TOWN AND COUNTRY PLANNING ACT 1990 FULL

Reference: H16-1072-24 **Date of Decision:** 10th September 2025
Applicant: Welcare Global Ltd.
Unit 1 Listerhills Science Park
Campus Road
Bradford
BD7 1HR
Location: The Grange 8 Pinchbeck Road Spalding
Description: Proposed change of use from vacant offices to 3 residential children's care home (C2) units

Address		
8 Pinchbeck Road		
Drawing Title		
Proposed Front Elevation		
Scale: 1/100 @ A3	Drawn: MI 22/10/24	
Drawing No:	007	Rev

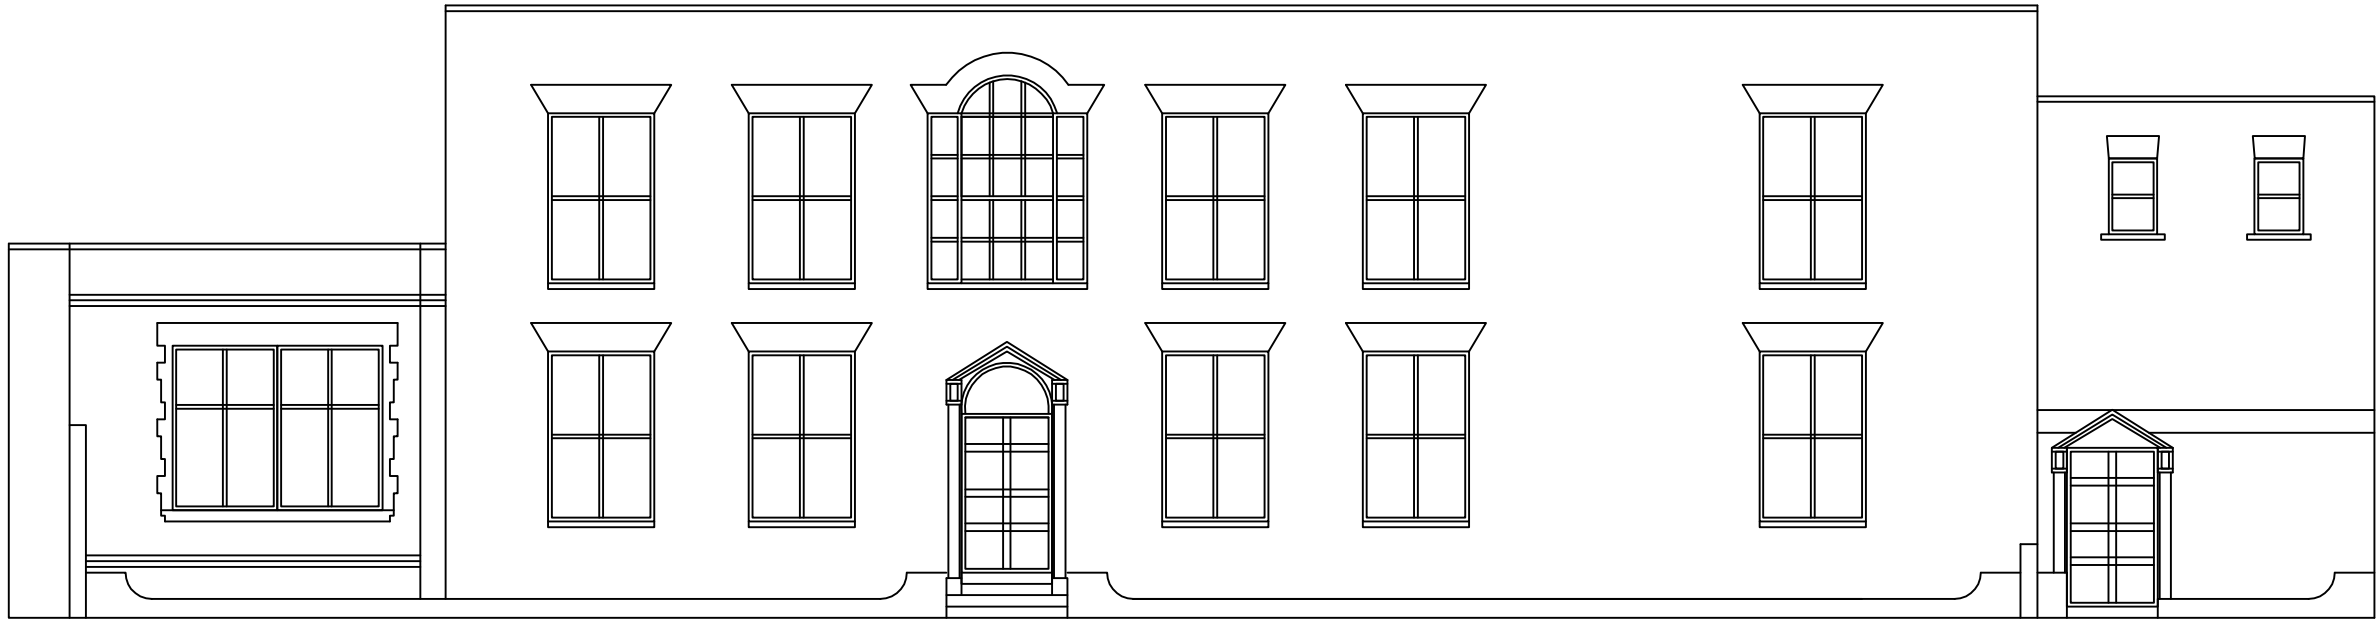
- 5 Details of the proposed door surround to the additional door proposed to be situated on the front elevation (indicated on plan 007) shall be submitted to and approved in writing by the Local Planning Authority prior to its installation. Such details shall indicate, at a scale of not less than 1:10, the elevation, longitudinal and cross-sectional detailing inclusive of pilasters and pediment. The doors and door frames shall be installed in accordance with the approved details and thereafter so maintained.

Note: The applicant is advised that the proposed surround and door should match as closely in style the extant, original front door.
